Our ref: A417
Your ref: TR010056

A417 Missing Link Development Consent Order

Application for a non-material change to an accepted Development Consent Order to include additional land for compulsory acquisition

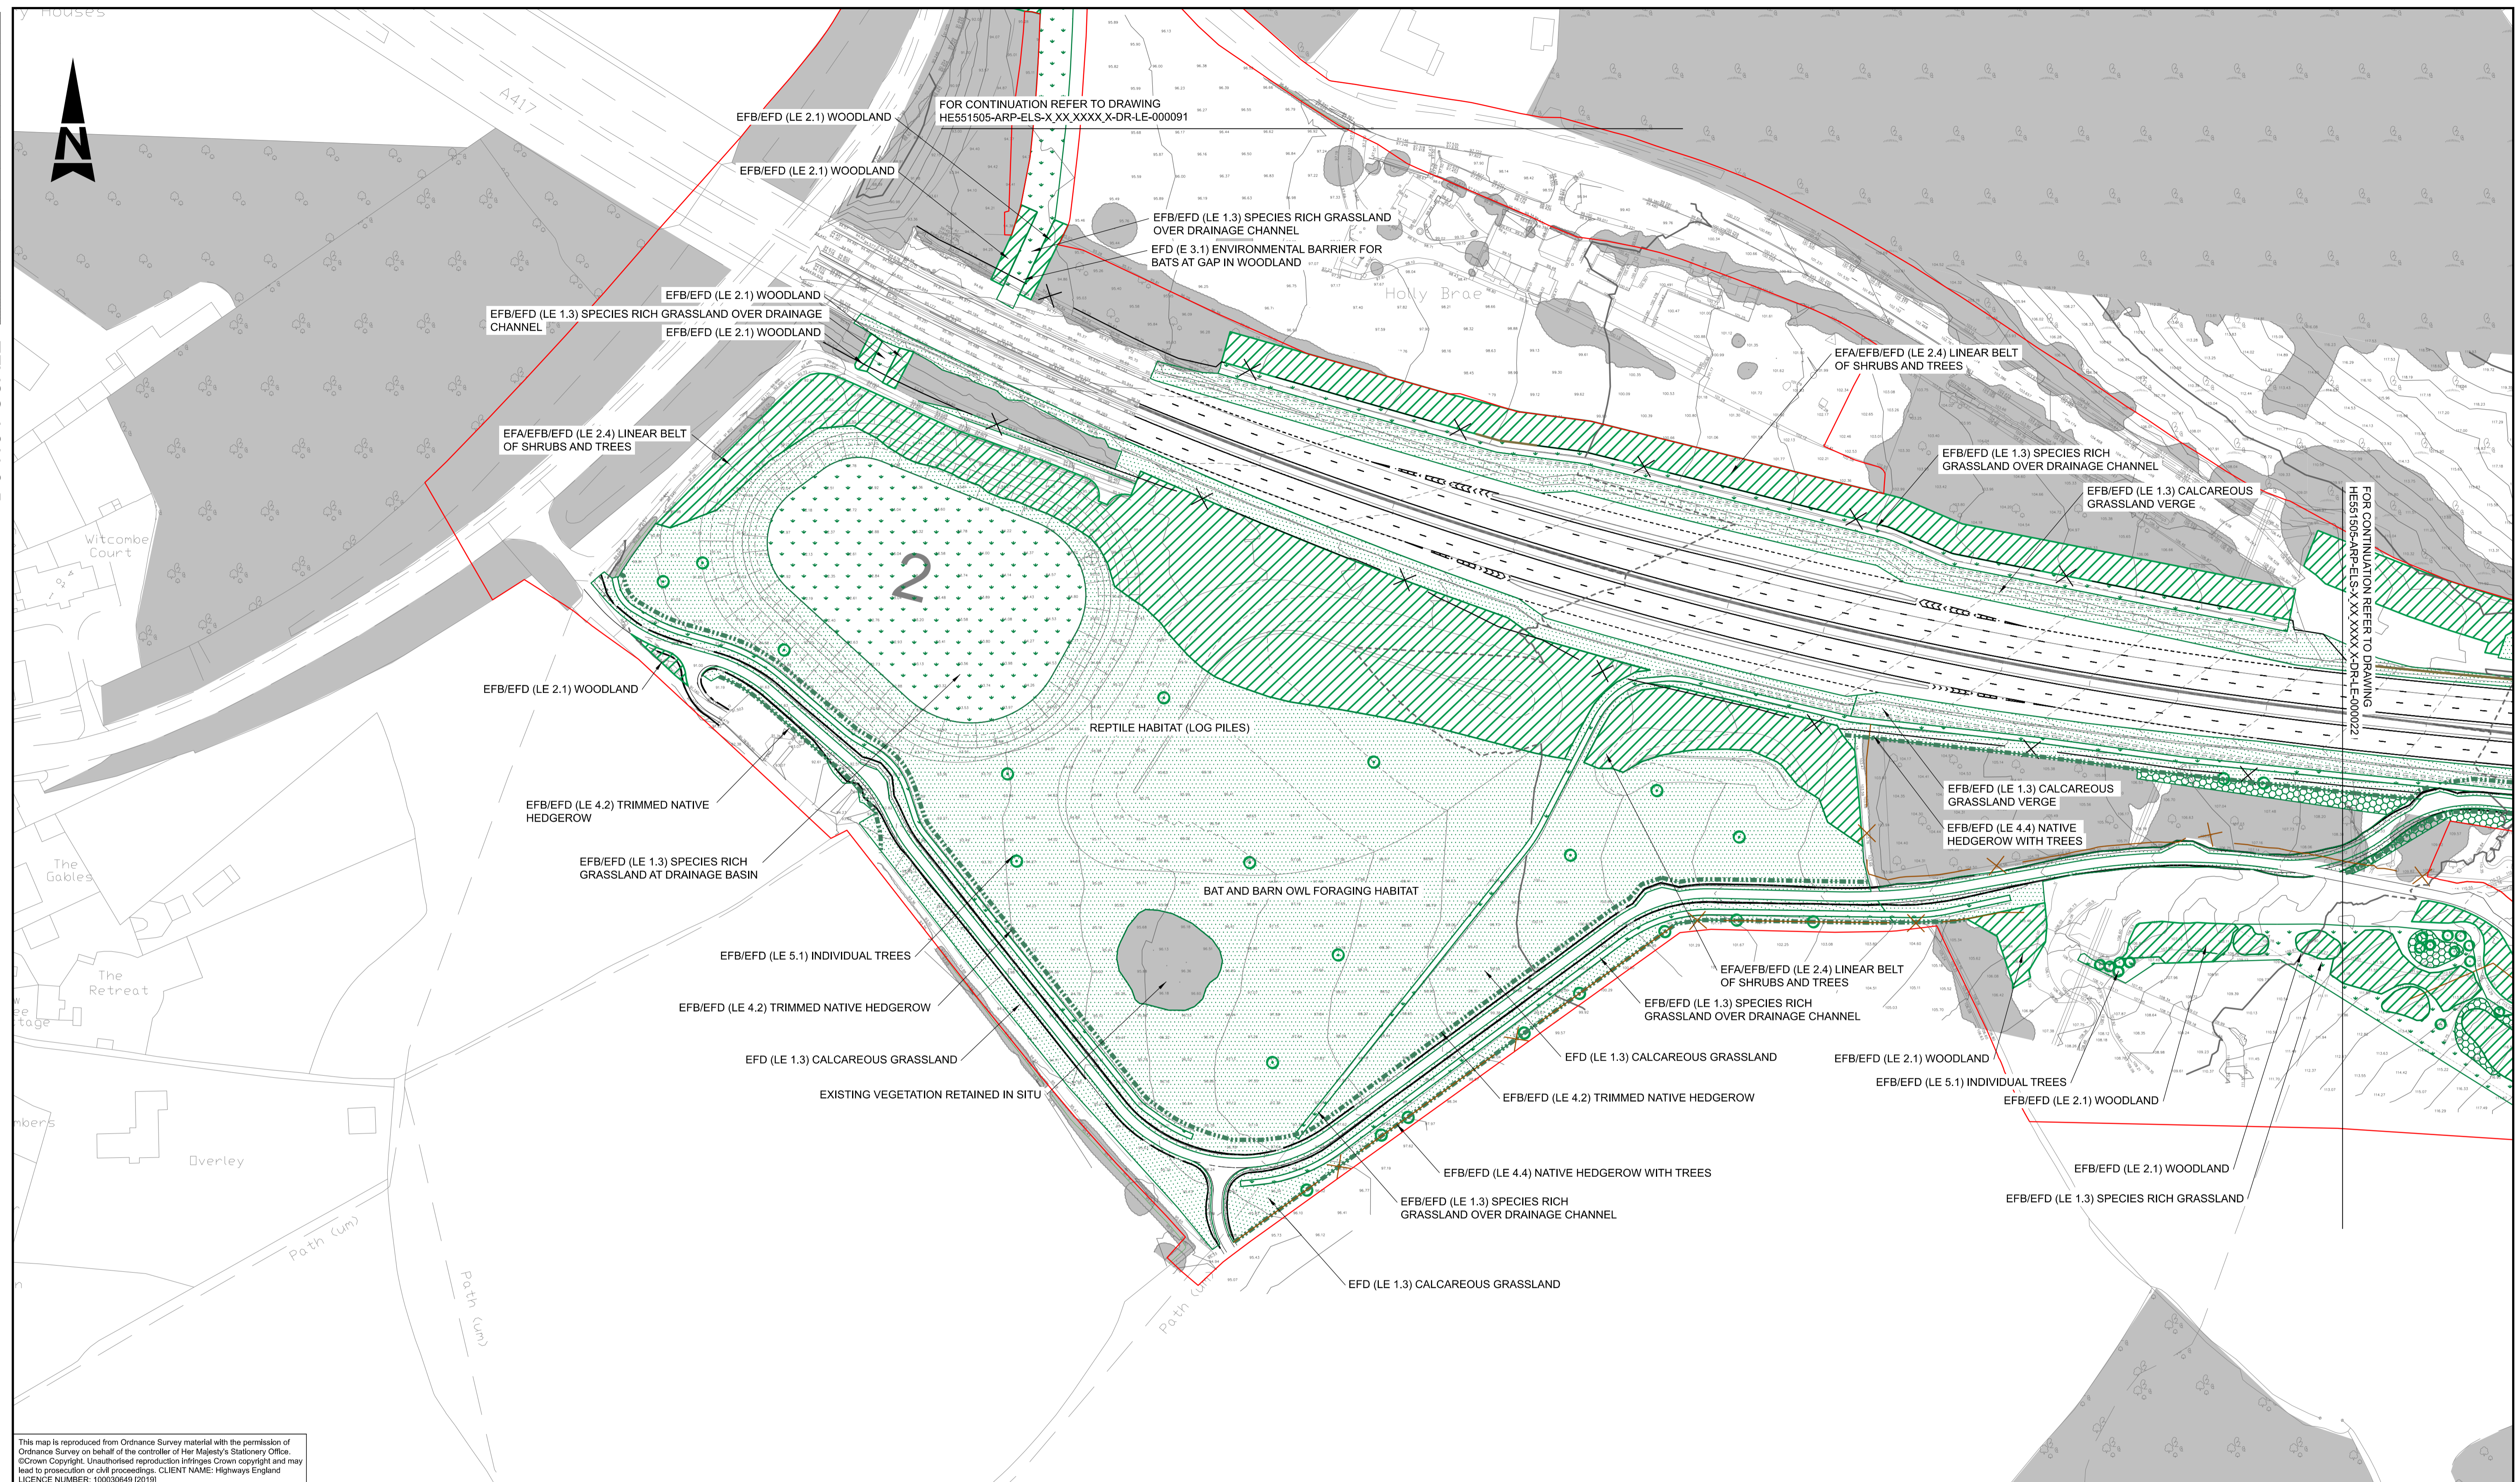
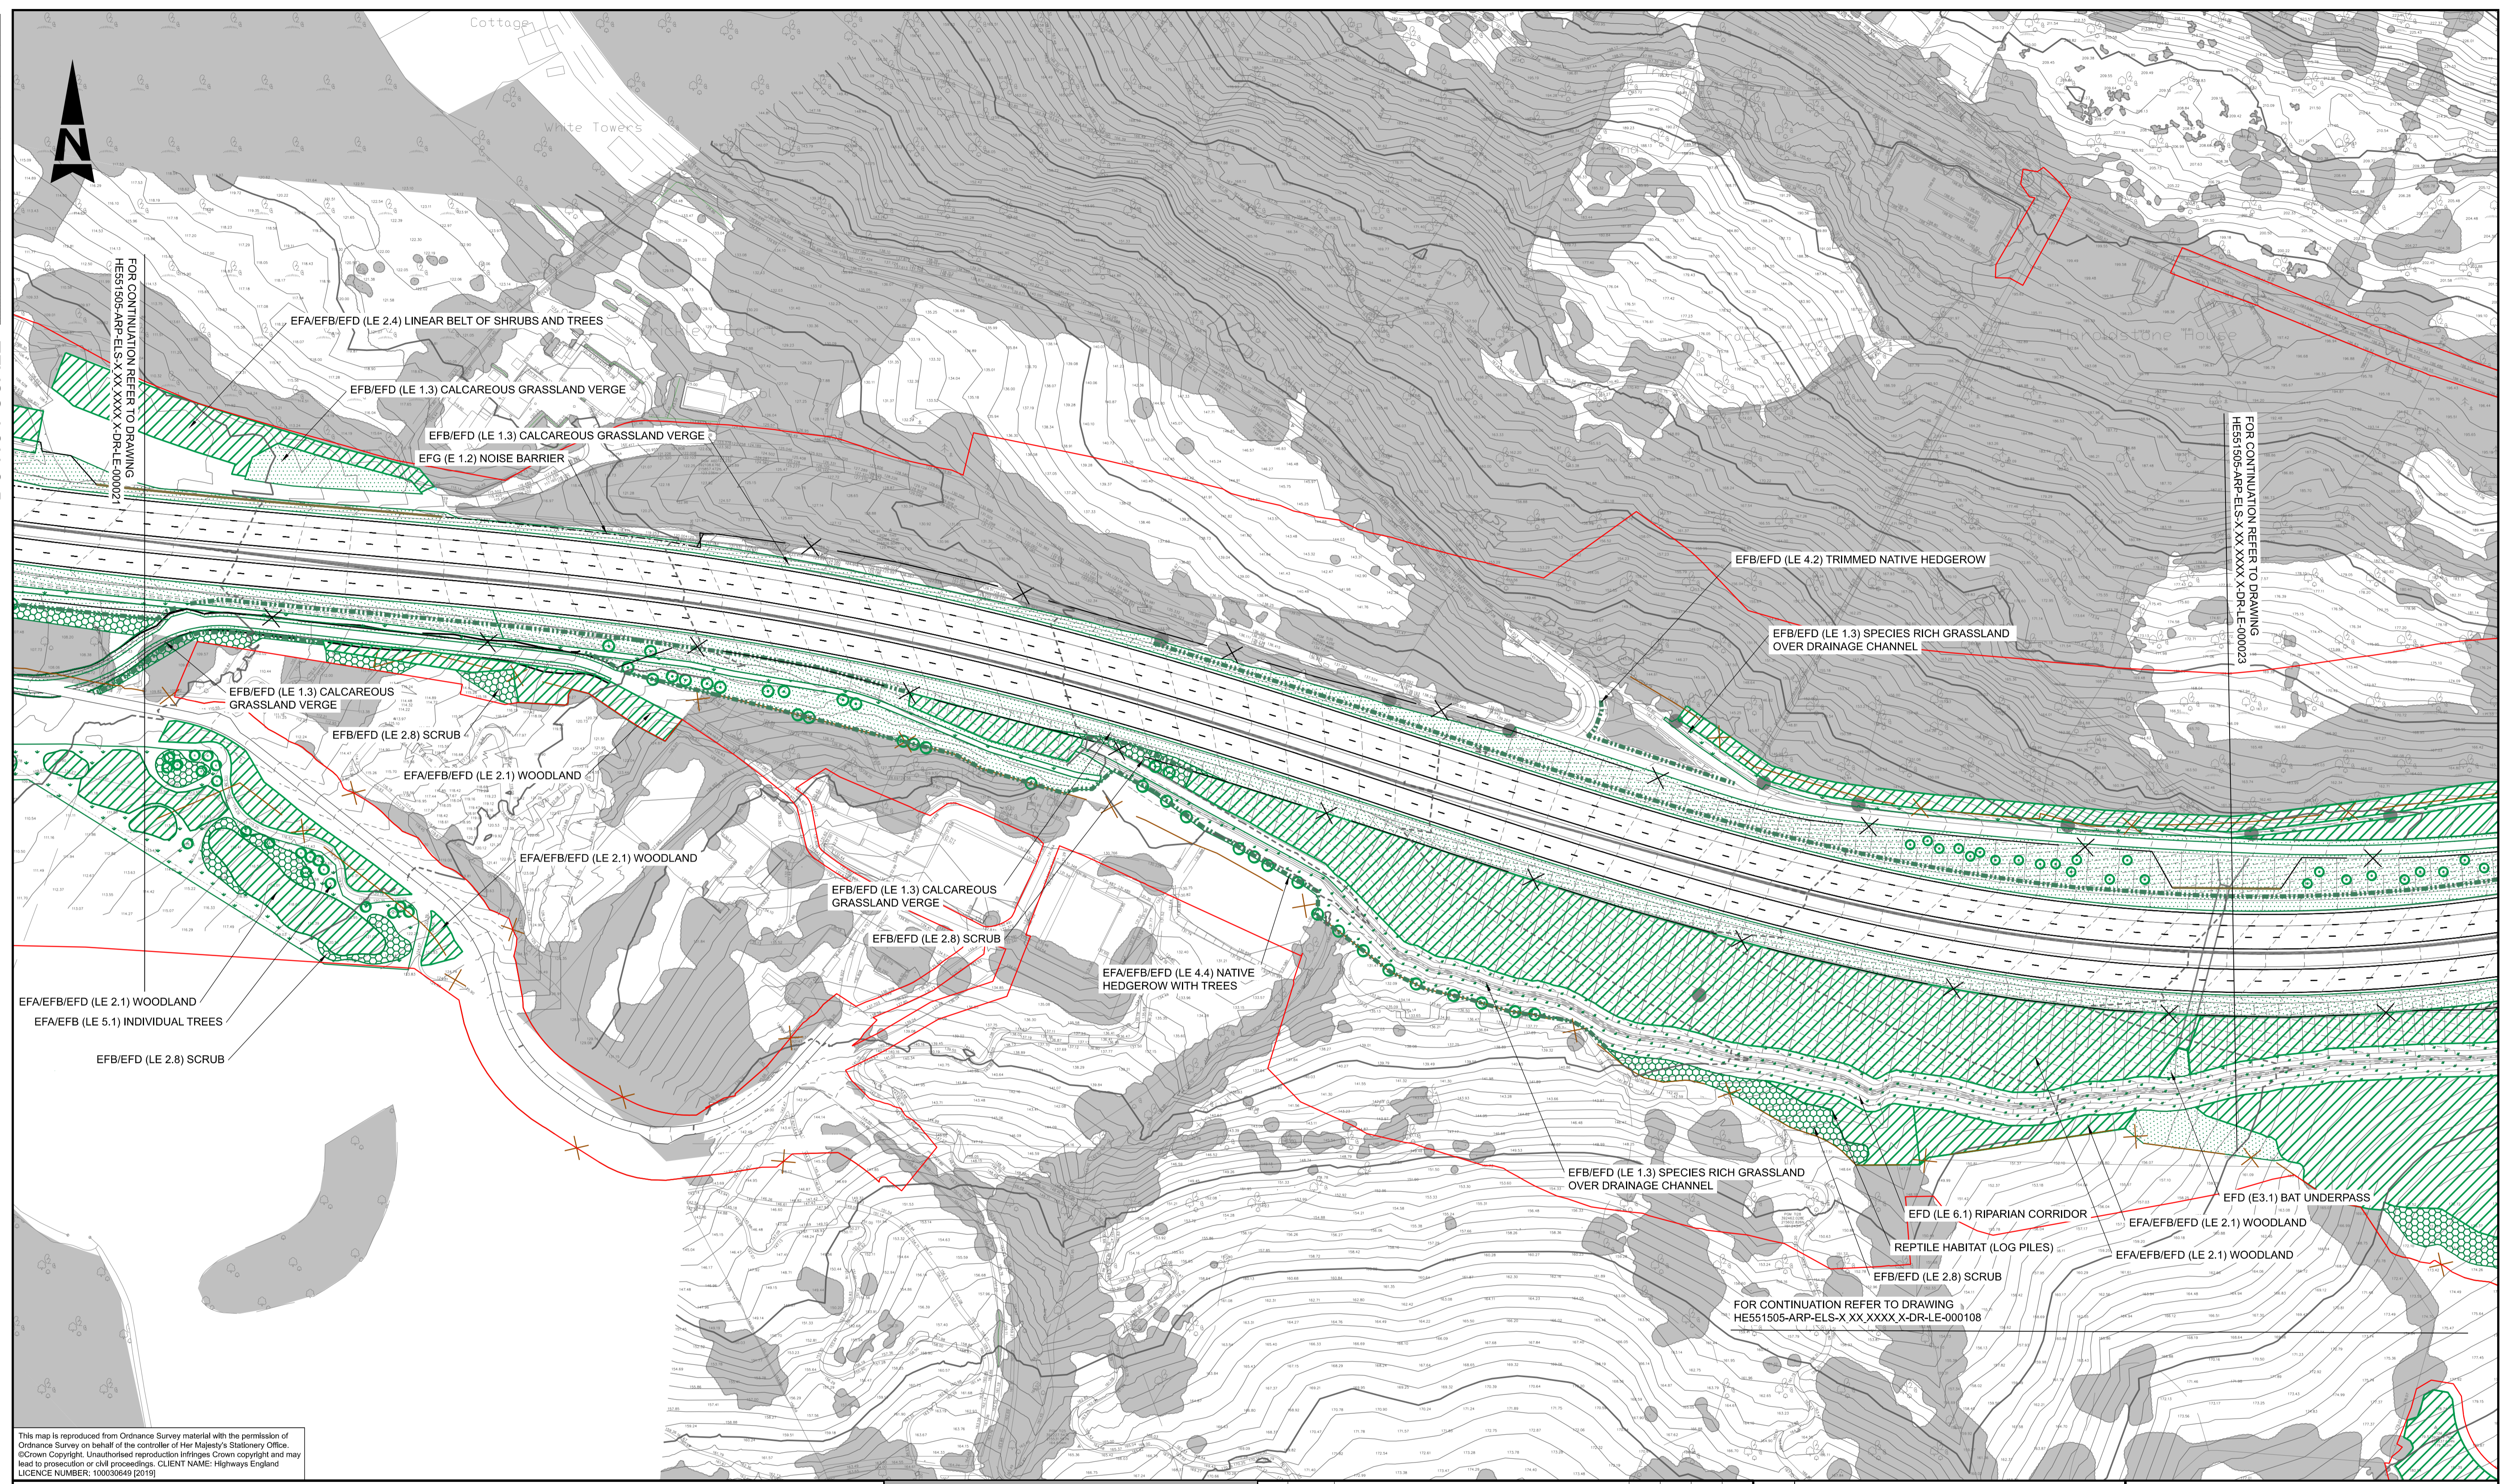
- 3.2 Having reviewed the ES, the main potential area for change related to revised mitigation planting:
- (a) Mitigation planting proposed to screen the mainline from key views is to be relocated from an area adjacent to the A417 to an area to the south of the proposed access road. Given this mitigation would be relocated as part of the change, no material change to likely significant effects presented in the Landscape and Visual Assessment is expected (Document Reference 6.2, Chapter 7, APP-038).

- (b) Mitigation planting proposed to offset vegetation loss along the A417 is to be relocated to the southern edge of the A417 to the plot southwest of Flyup business, adjacent to existing downhill bike tracks. Given this mitigation would be relocated as part of the change, no material change to likely significant effects presented in the ecological assessment is expected (Document Reference 6.2, Chapter 8, APP-039).

| Document | Reference | Change(s) |
|--|--------------------------------|---|
| Environmental Masterplan (Sheet 2 of 25 and 3 of 25) | Document Reference 6.3, Rev 1 | Changes to the proposed areas of planting at Flyup Ltd due to the design changes proposed and introduction of a new 'business / customer access' in between the |

| Document | Reference | Change(s) |
|---|---|---|
| | | proposed A417 and the residential property. |
